Application H18-1088-23
Location The Curlew Centre 51 Bridge Road Sutton Bridge PE12 9SA
Proposal Proposed sports pavilion/leisure centre

Name Diane Fairchild
Address Conservation Assistant (Tree Preservation) Planning & Development

Indicative plans

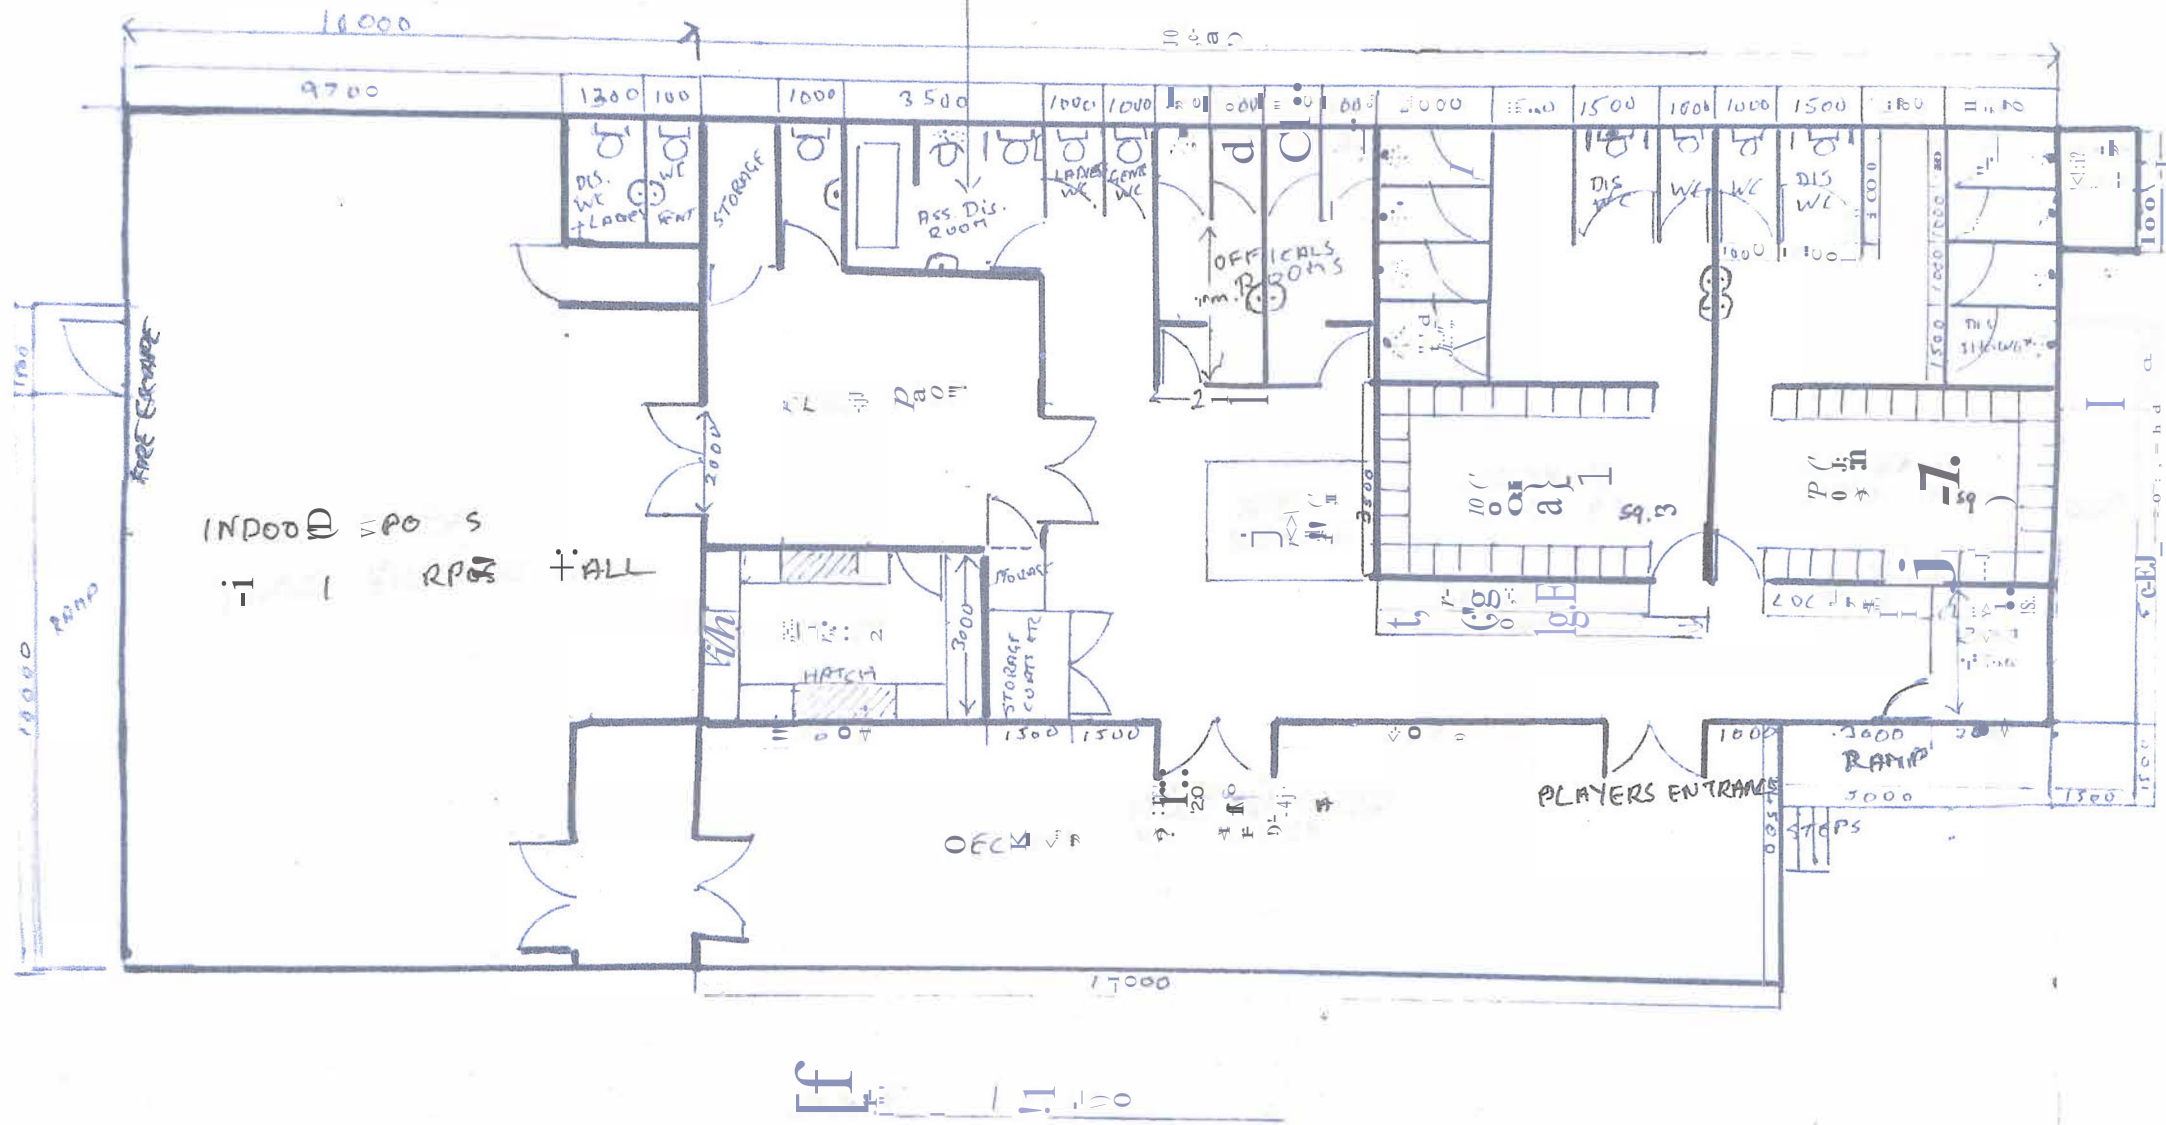
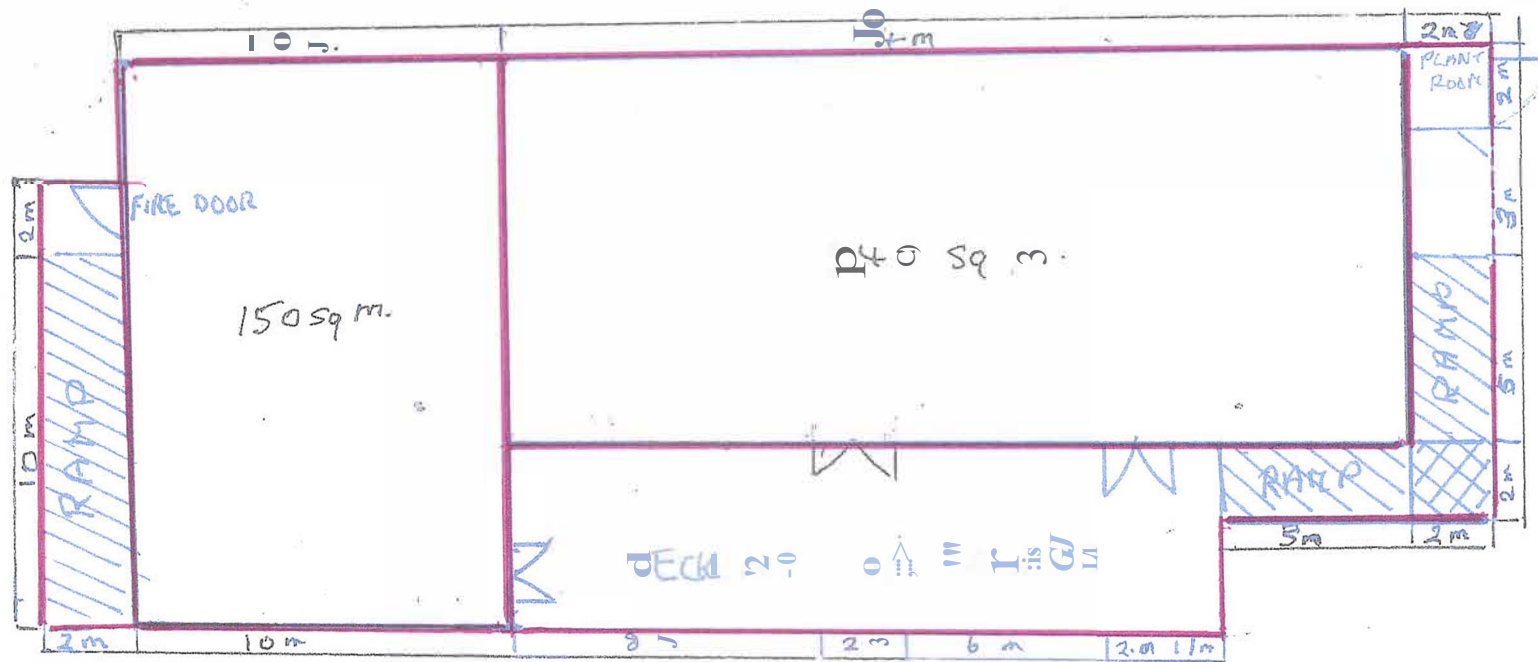
AM ASSUMING THAT THE TREES (WHEN MATURE) CLOSEST TO THE PROPOSED BUILDING ARE NOT WITHIN FALLING DISTANCE OF THE BUILDING; IF THEY ARE; IDEALLY ADJUSTMENTS COULD BE MADE TO THE PROPOSED BUILDING LAYOUT AT THIS STAGE TO ENSURE CLEARANCE.

DESIGN ANY GUTTERS TO RESIST DEBRIS FROM TREES.

BUILDING MAY OFFER SOME OPPORTUNITIES FOR BIRD NEST BOXES TO BE ATTACHED.

DRIVEWAY, IF WITHIN ROOT PROTECTION AREAS OF TREES (BRITISH STANDARD 5837:2012), TO BE OF NO-DIG CONSTRUCTION.

IMMEDIATELY PRIOR TO AND DURING CONSTRUCTION IDEALLY CLOSEST TREES TO DEVELOPMENT TO BE FENCED AS IN BRITISH STANDARD 5837:2012. TO PROTECT THEM DURING CONSTRUCTION OF PROPOSED BUILDING.

(NOTHING TO DO WITH PLANNING CONSIDERATIONS WHATSOEVER; WOULD HAVE THOUGHT THAT IN THE LONG TERM A ROOF WITH A SLIGHT PITCH ON IT WOULD HAVE BEEN MORE WEATHER RESISTANT THAN THAT PROPOSED, WHICH APPEARS TO BE A FLAT ONE.)
